SMOKE STACK AT STERLING RANCH

SMOKE STACK AT STERLING RANCH REZONE

REZONE EXHIBIT

P2310

REZONE EXHIBIT

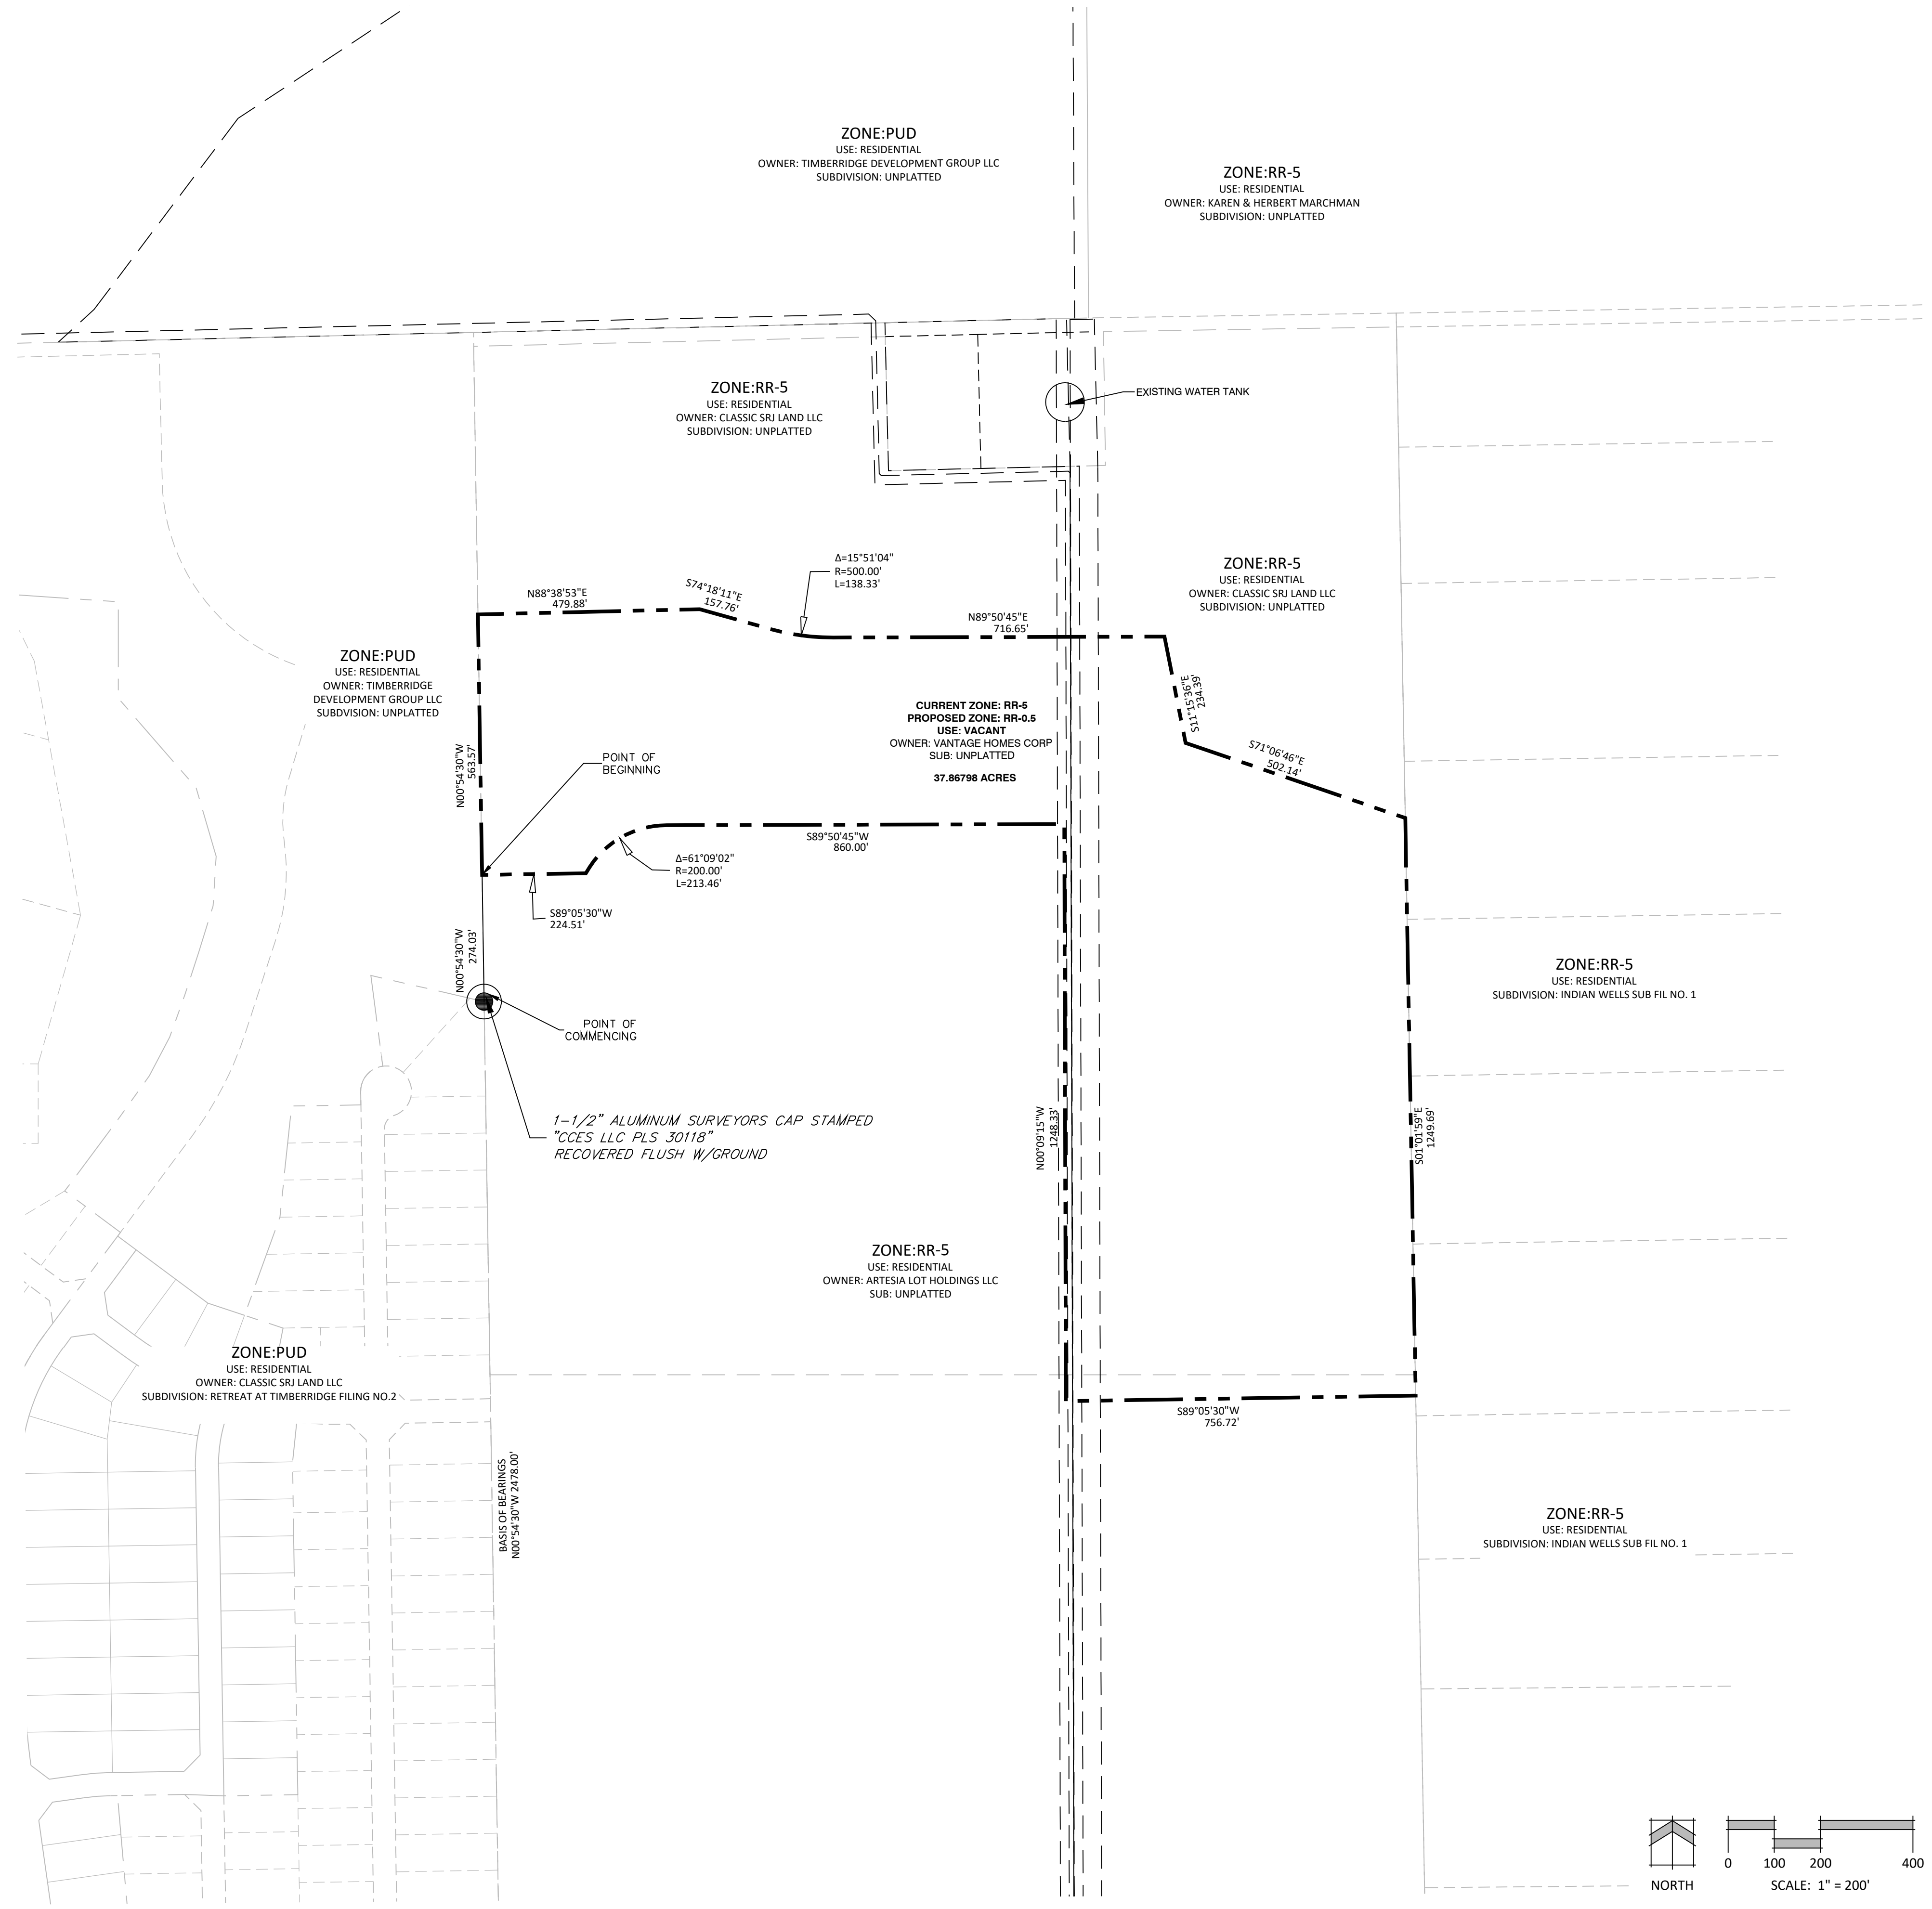
Add existing easements, etc.
per checklist please

2023 file if approved

please identify subdivision names for clarity

provide acreage

NES: Added.

NES: This is reflecting the current approved Sketch Plan that we are amending. Label has been updated. Once this next amendment is approved then it will replace this current file number and approval date.

NES: This has been provided and additional labels have been added.

EASEMENT
NES: Added. Please reference new linetype legend.
